A47 Blofield to North Burlingham

Scheme Number: TR010040

8.13 Statement of Common Ground with Highways England and Blofield Parish Council

Statement of Common Ground – Blofield Parish Council

HE551490-GTY-HGN-000-DR-CH-30019

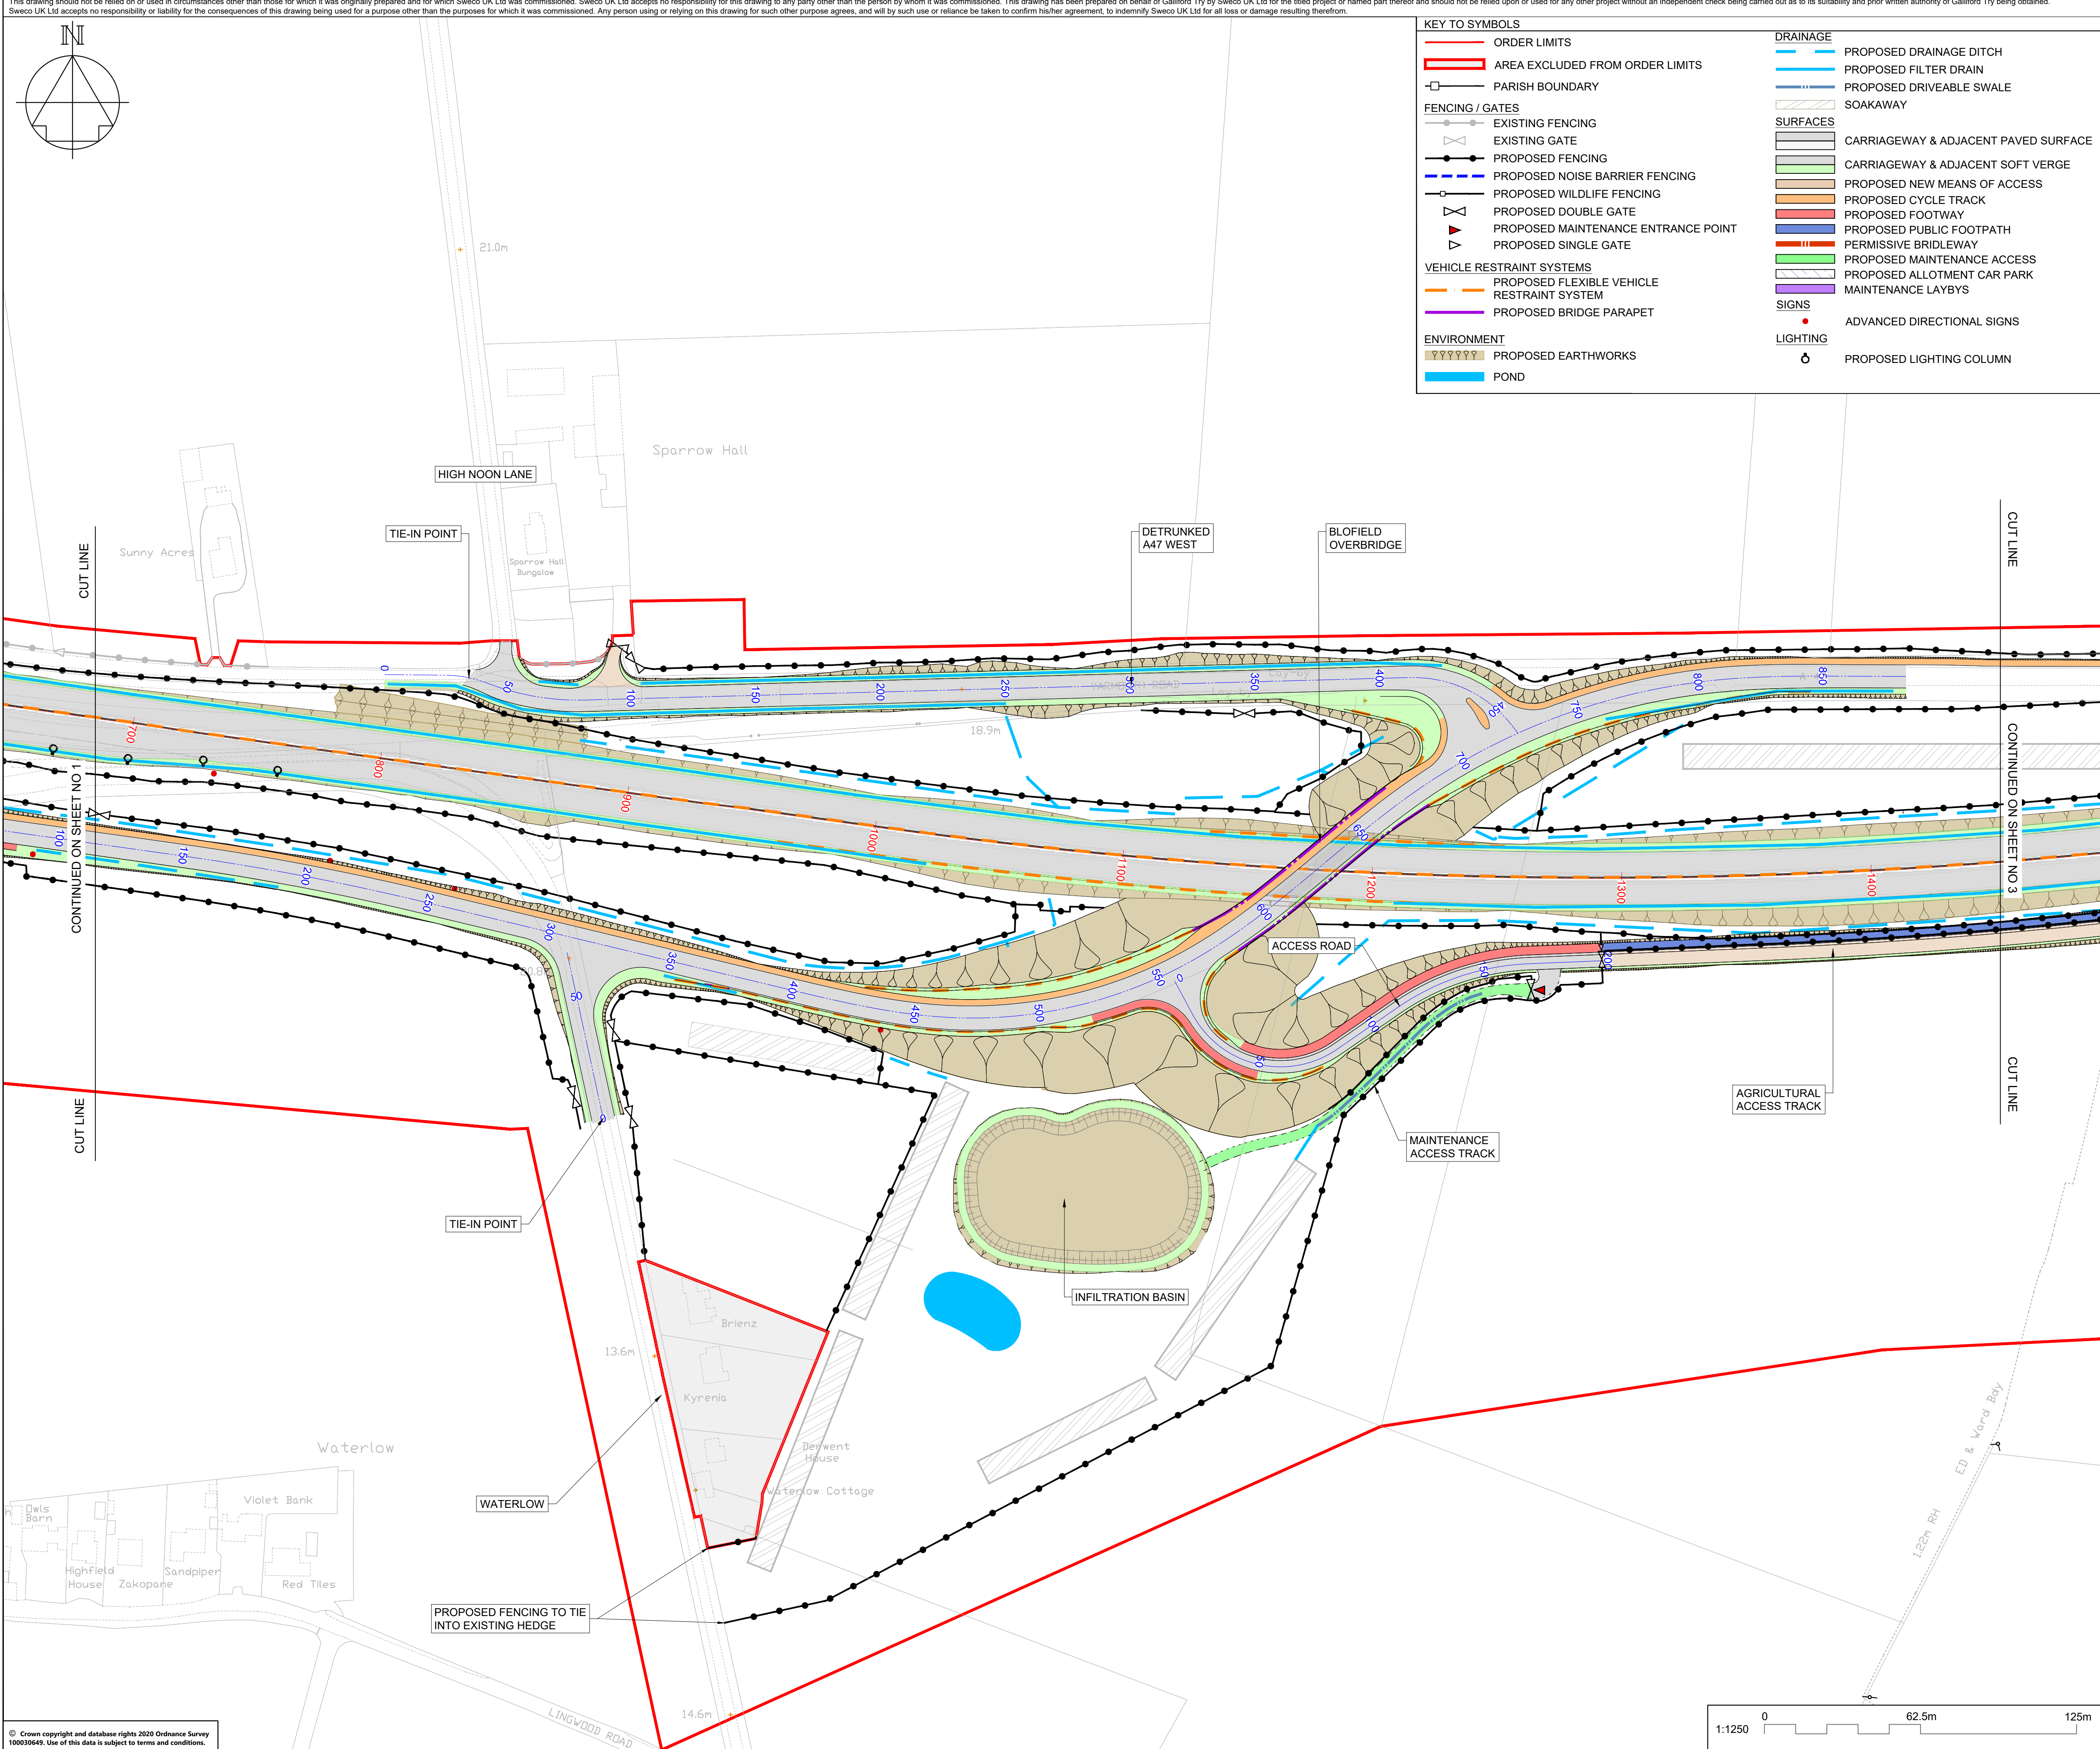
Road Lighting	Letter from BPC in Appendix C	2.6 General Arrangement Plans The proposed 20 lighting columns would be in contradiction of the Blofield Neighbourhood Plan	As described in the Scheme Design Report (APP-122) lighting is proposed at the Yarmouth Road as road safety mitigation.
